City of Portland, Maine - Building or Use Permit Application
 389 Congress Street, 04101 Tel: (207) 874-8703, Fax: (207) 874-8716

Permit No: 04-0478	Issue Date:	CBL: 058 A002001
------------------------------	--------------------	----------------------------

Past Use: Single Family	Proposed Use: Single Family w/ interior alterations, new windows and doors, add new deck	Permit Fee:	Cost of Work: \$0.00	CEO District: 2
Proposed Project Description: Do interior alterations, new windows and doors, add new deck		FIRE DEPT: <input type="checkbox"/> Approved <input type="checkbox"/> Denied	INSPECTION: Use Group: Type	
		Signature:	Signature:	
PEDESTRIAN ACTIVITIES DISTRICT (P.A.D.)				
Action: <input type="checkbox"/> Approved <input type="checkbox"/> Approved w/Condition <input type="checkbox"/> Denied				
		Signature:	Date:

Dept: Zoning **Status:** Approved with Conditions **Reviewer:** Tammy Munson **Approval Date:** 05/28/2004
Note: **Ok to Issue:**

1 FIRST FLOOR PLAN

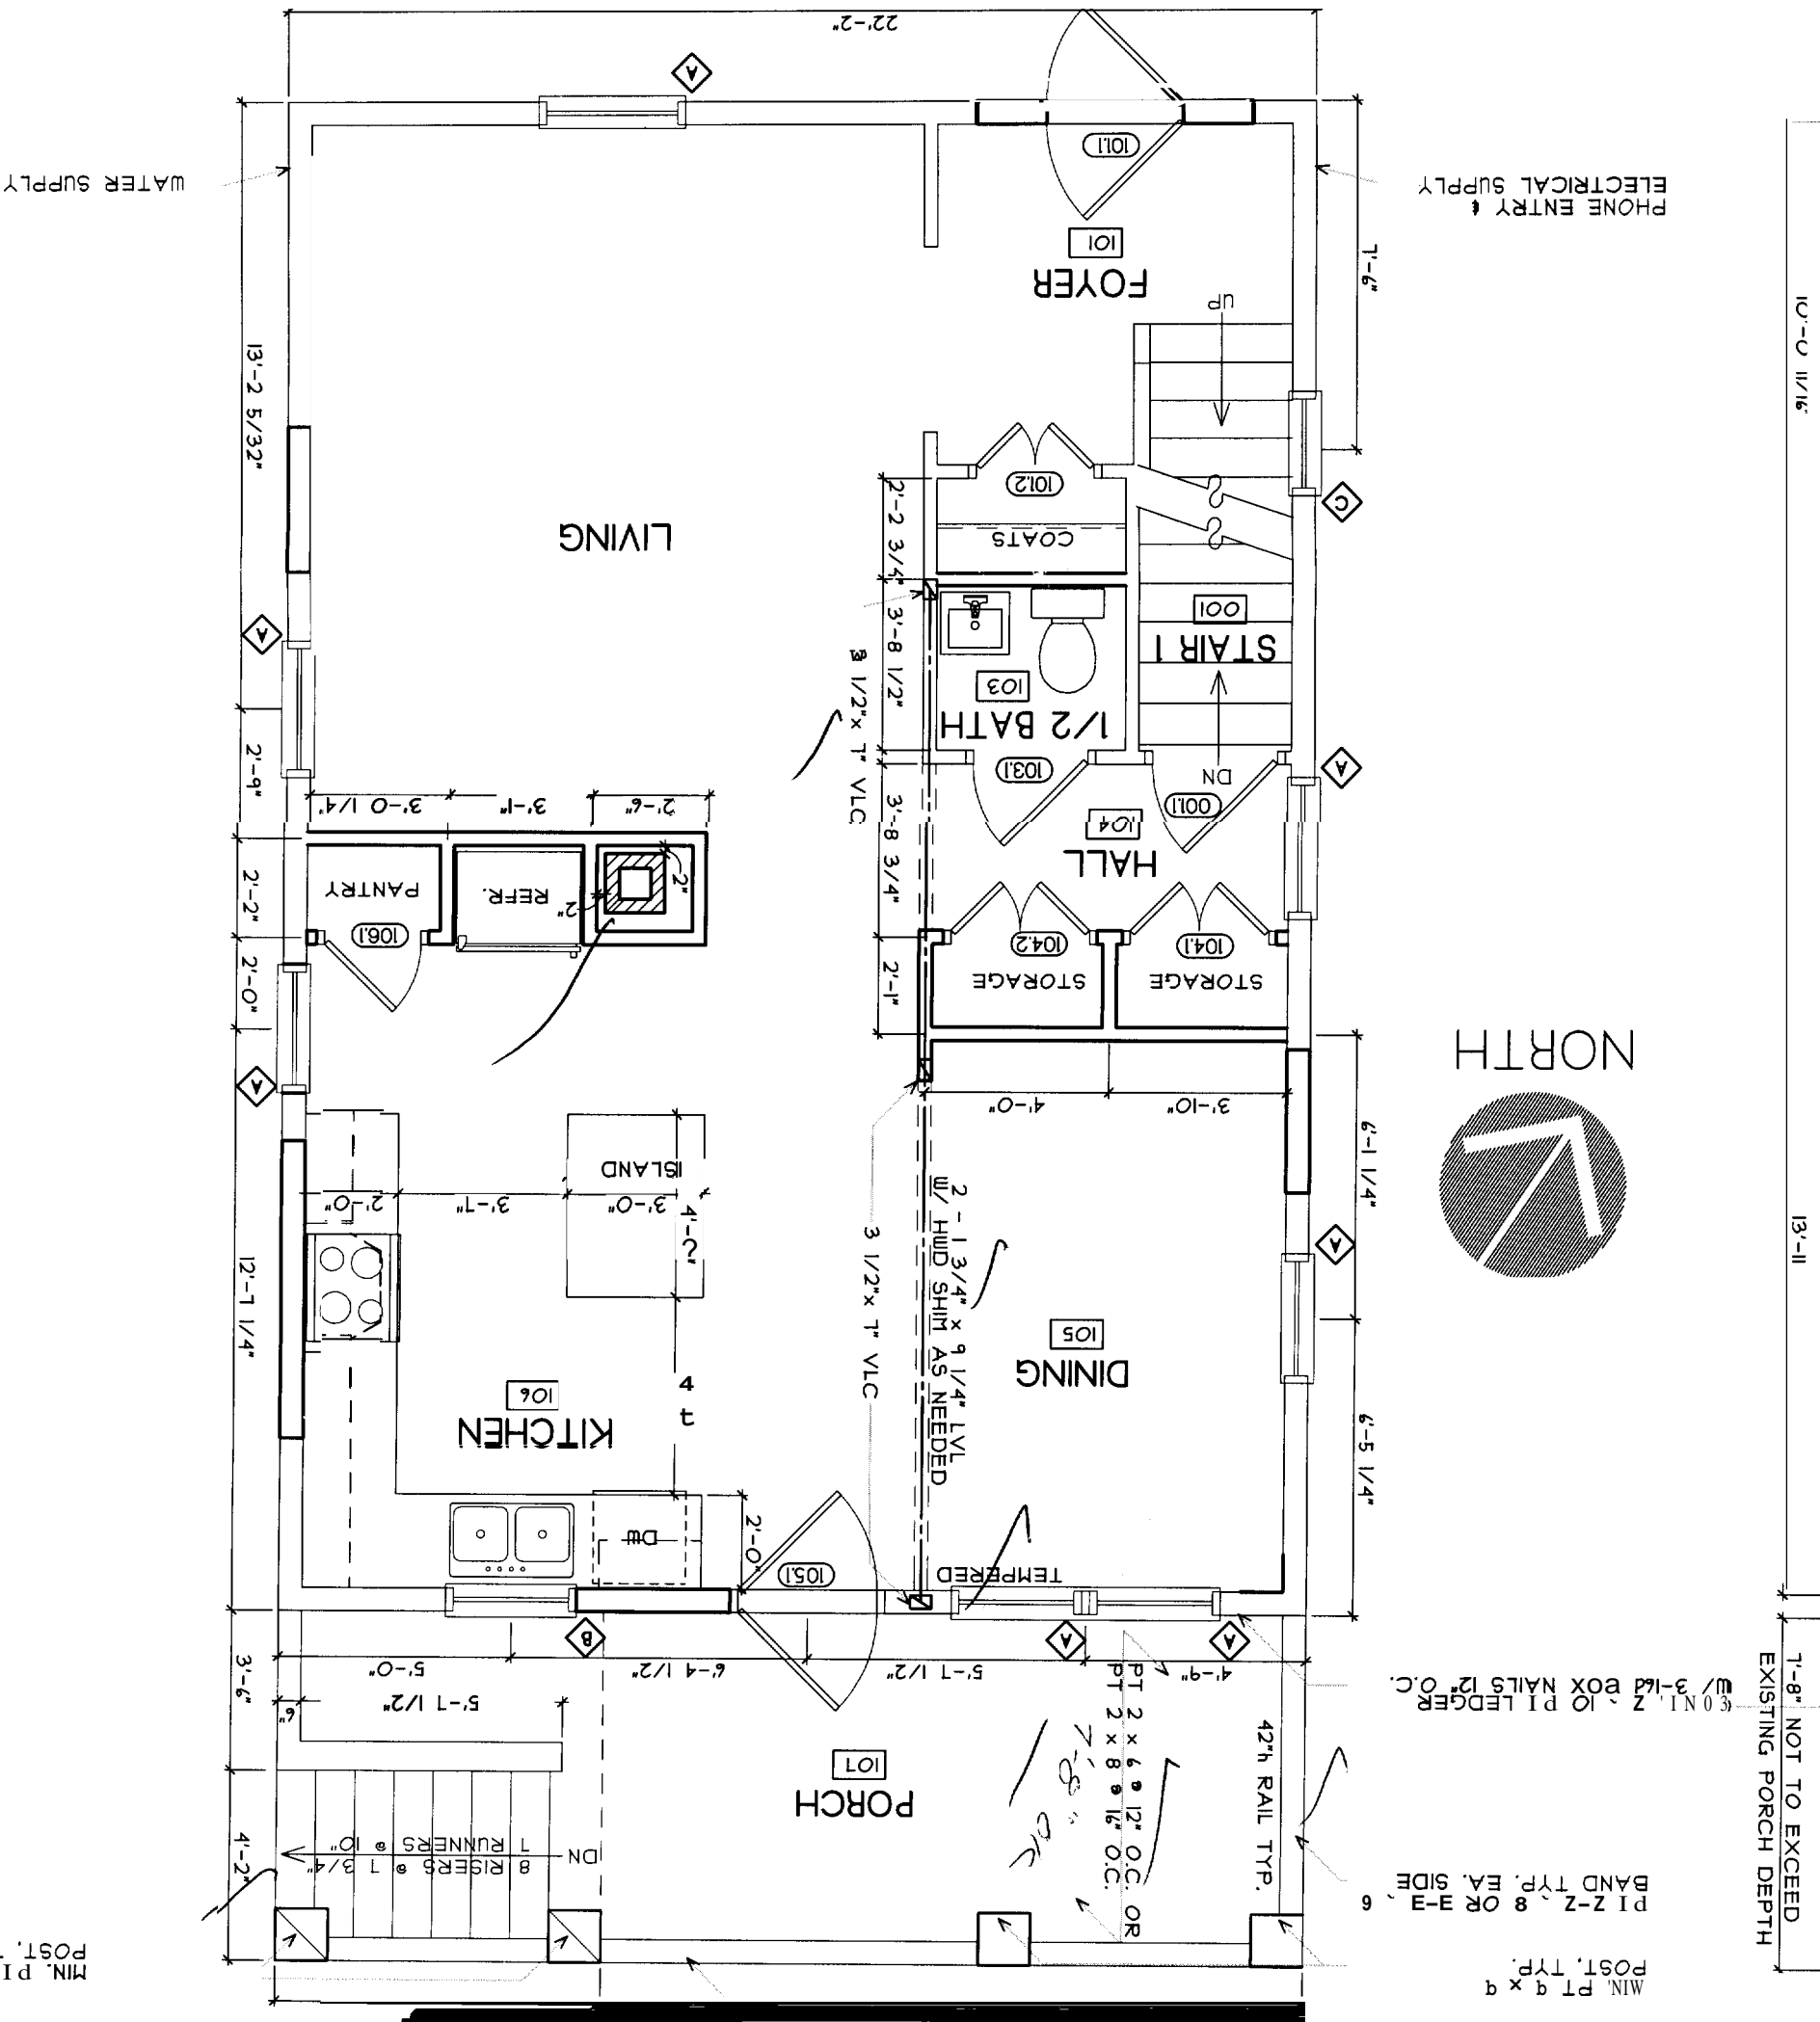
- 1) As discussed during the review process, all bedrooms must have egress windows.

3 BASEMENT POST DTL

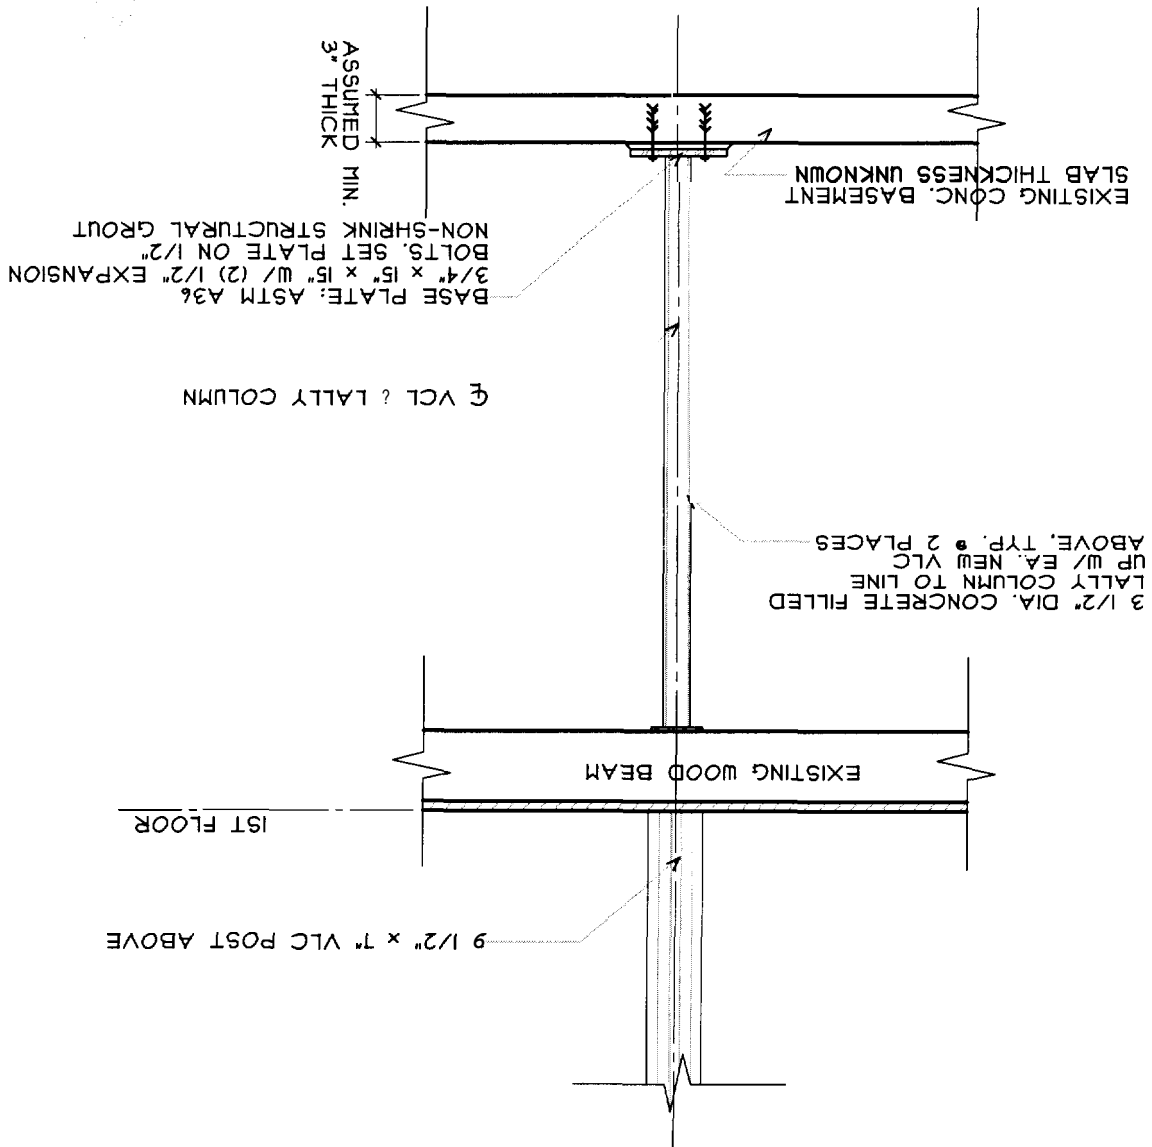
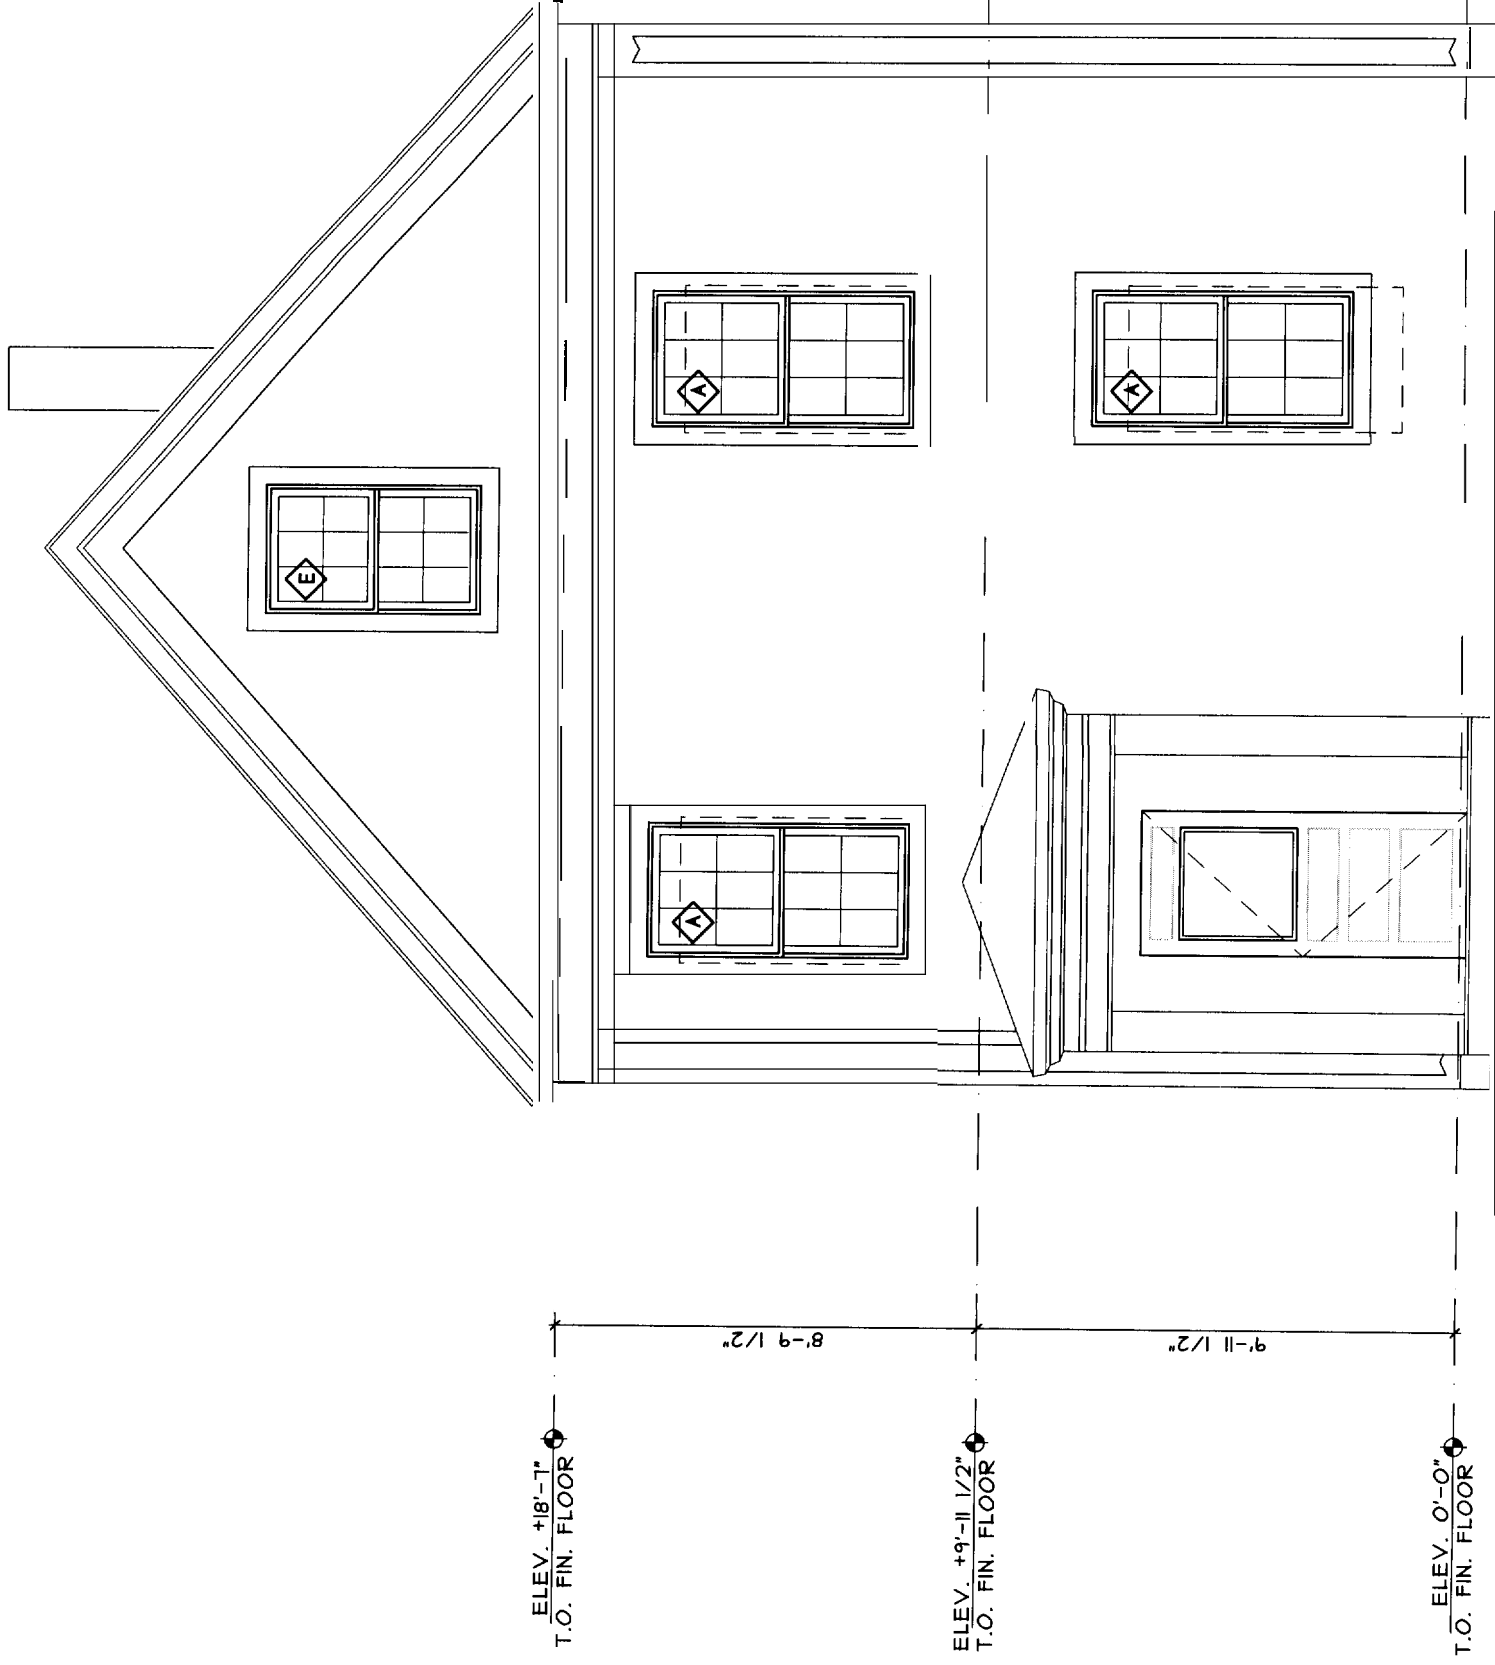
5/7/04-tmm: met w/owner - still need structural info on plans - will obtain and return.
